**Our Case Number:** ABP-319307-24  
**Your Reference:** Laurclavagh Limited

An  
Coimisiún  
Pleanála

**Re:** Proposed no 8 wind turbines and associated works.  
Laurclavagh and adjacent townlands, Co. Galway. ([www.laurclavaghplanning.com](http://www.laurclavaghplanning.com))

Drawing Title: Black-head Gull Observations Vantage Point Surveys	
Project Title: Laurdavagh Renewable Energy Development	
Drawn By: KS	Checked By: PM
Project No.: 210627	Drawing No.: 7-4-15
Scale: 1:50000	Date: 09.11.2023

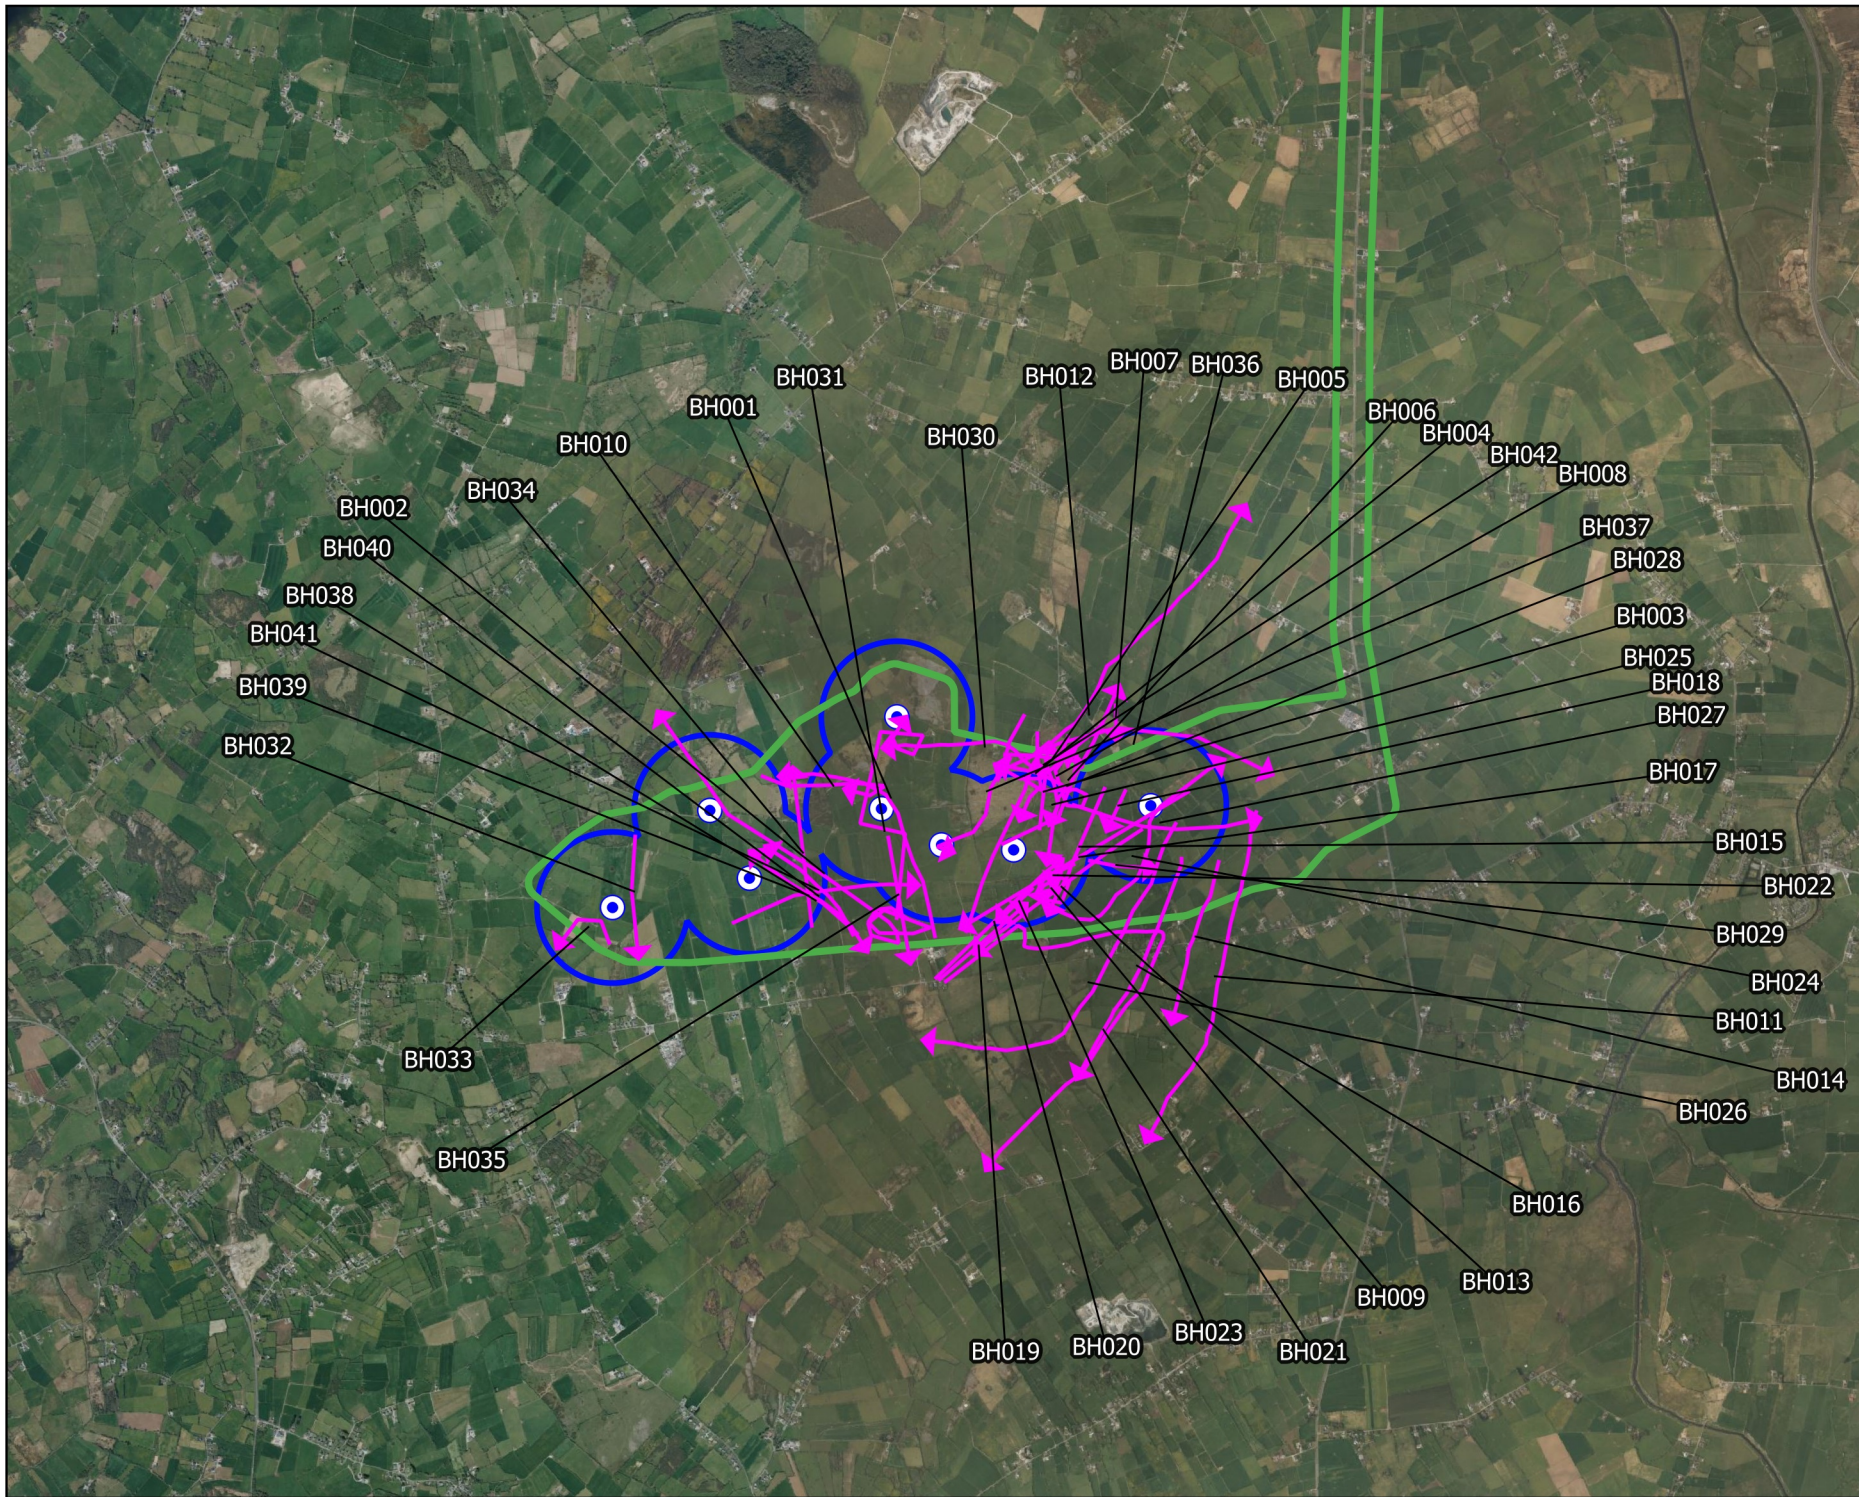
Notwithstanding the updated collision risk assessment provided in the EIAR Addendum, the Department of Housing, Local Government and Heritage (DHLGH/DAU), in its post-Further Information submission dated 4 December 2025, has confirmed that the revised NIS continues to contextualise Black-headed Gull collision mortality against county-level population figures rather than against the relevant breeding population of Lough Corrib SPA.

- i) A revised collision risk assessment for Black-headed Gull that expresses projected annual collision mortality as a proportion of the Lough Corrib SPA breeding colony population, consistent with the requirements of Percival (2003) as clarified by the DHLGH in its submissions of 9 May 2024 and 4 December 2025.
- ii) Confidence intervals (at minimum 95% confidence level) around all CRM output figures for Black-headed Gull, including both the stochastic and

iii) Evidence demonstrating whether Black-headed Gulls recorded on or in transit through the proposed wind farm site during the breeding season (April to August inclusive) have been assessed as associated with the Lough Corrib SPA breeding colonies, with reference to the 18.5 km mean maximum foraging range specified in the NPWS conservation objectives for the SPA (NPWS, 2023). If such an assumption is contested you must provide scientific justification to support an alternative population attribution.

iv) Confirmation of the total breeding population figure used as the denominator in the revised CRM and the source documentation for that figure. Where this figure is based on NPWS survey data the relevant survey year and methodology must be cited.
